Rezoning Transportation Analysis

Petition Number: #2022-070

General Location Identifier: 02505103, 02505102

The petition is located on the west side of Old Statesville Road, a State-maintained major throughfare south of Vance Davis Drive, a City-maintained major collector. A Traffic Impact Study (TIS) is needed for this site. The TIS was approved by CDOT and NCDOT on January 31, 2023. Site plan revisions are needed to meet ordinance requirements and/or the outstanding items including removing the phasing of the transportation improvements or providing a revised TIS. Further details are listed below.

**RZ-2.0**

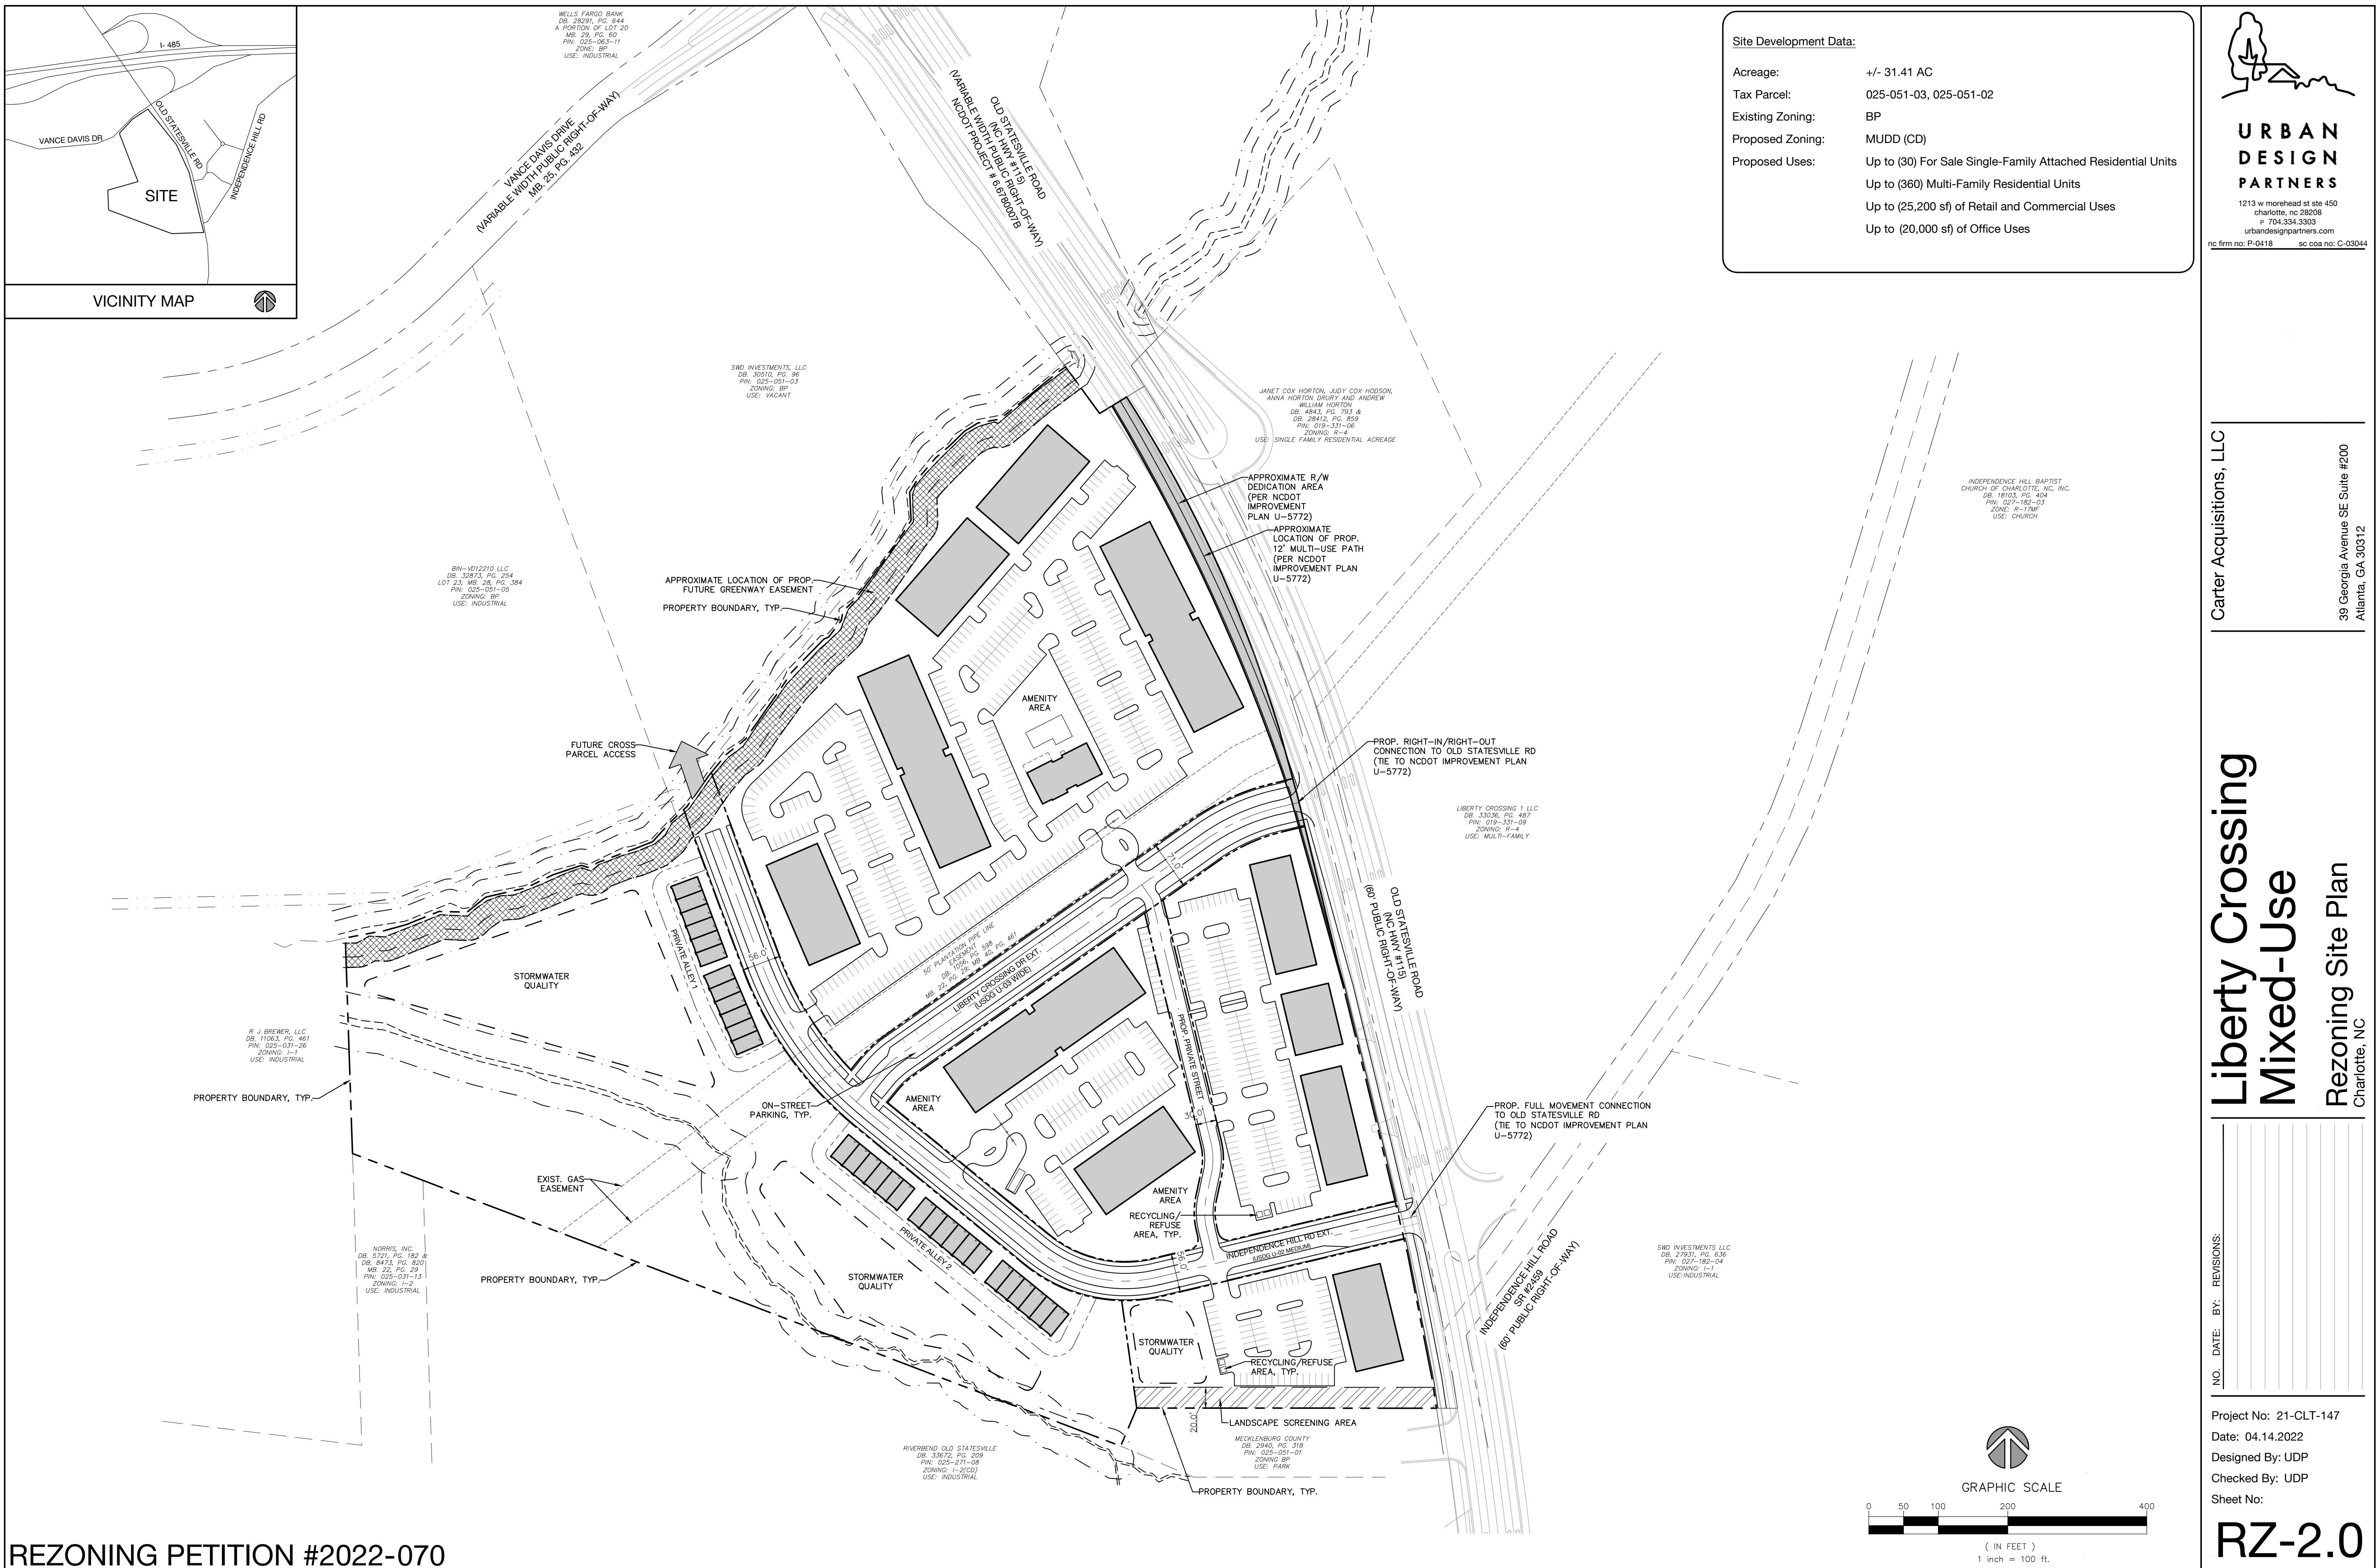
1. ~~**Curbline:** The proposed zoning district has a setback measured from back of the existing or proposed future curbline.~~
 - a. ~~**Old Statesville Road:** The future location of the back of curb and gutter shall be located at minimum 36 feet from the centerline of the roadway.~~

~~**Outstanding Comment From 9-29-22:** Label and dimension the curb and gutter from the centerline for each road on the site plan.~~

- ~~3. Revise site plan to dimension the proposed right-of-way along Old Statesville Road to be dedicated. The ROW dedication shall include the necessary widths to accommodate the NCDOT U-5772 project.~~

Clarifying Comment (10-26-2022): Dimension ROW along Old Statesville Road from the centerline of the roadway.

10. **New Comment From 2-23-23:** The site plan submittal from 2/13/2023 includes phasing of the offsite transportation improvements but the traffic study was not phased. If the intent is to phase the

transportation improvements, then a revised traffic study will need to be provided. In addition, all offsite transportation improvements are to be completed prior to the Site's first certificate of occupancy.
